**Subject: Request for SEARs for Horsley Drive Business Park Stage 2 Buildings 2 and 3, corner Cowpasture Road and Trivet Street, Wetherill Park (SSD 17161650)**

## **FAIRFIELD CITY COUNCIL RESPONSE – SCOPING REPORT FOR SSD 17161650 - HORSLEY DRIVE BUSINESS PARK STAGE 2 BUILDINGS 2 AND 3**

**REQUEST FOR SEARS HORSLEY DRIVE BUSINESS PARK – STAGE 2 BUILDINGS 2 & 3 - CNR COWPASTURE ROAD AND TRIVET STREET, WETHERILL PARK**

**Horsley Drive Business Park Stage 2 – Buildings 2 & 3 – Request for SEARs (SSD 17161650)**

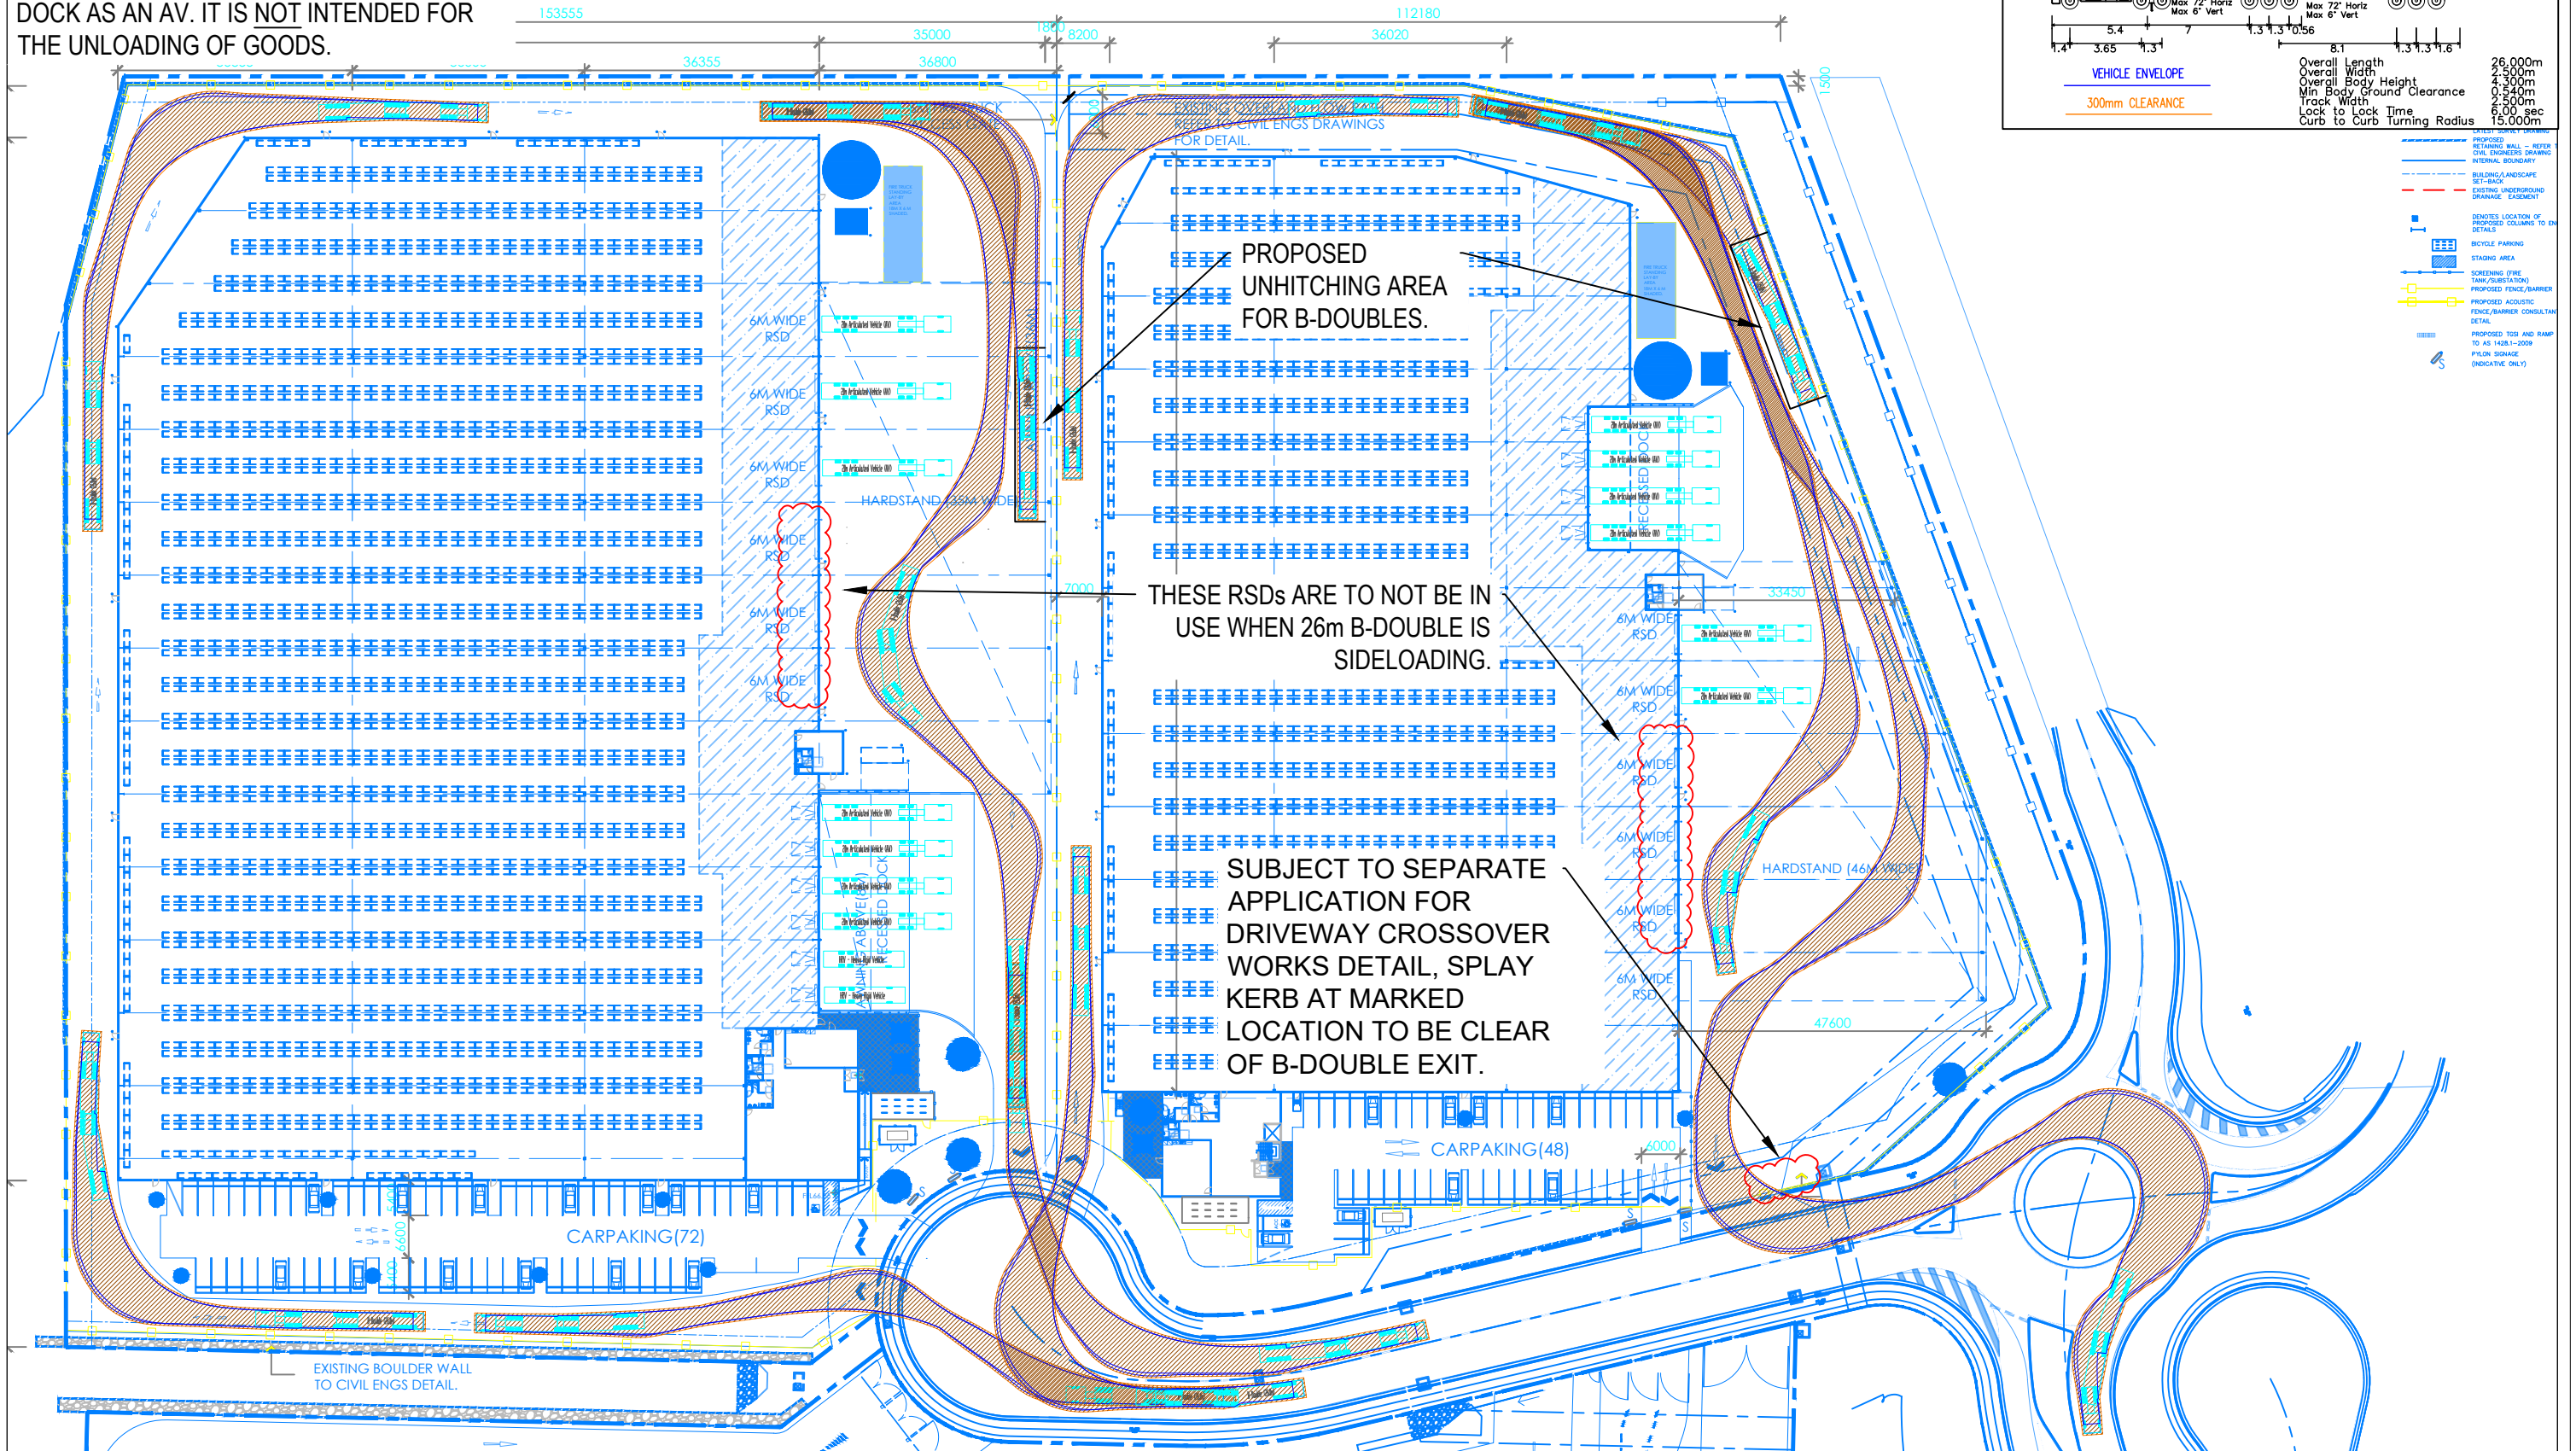
- C. Swept Path Diagram for Loading Docks** – For building 1 The swept path diagram shall demonstrate how the largest vehicle can maneuver into and out of the loading dock as well as how it can satisfactorily turn into and out of the site without impacting traffic on the external road network.
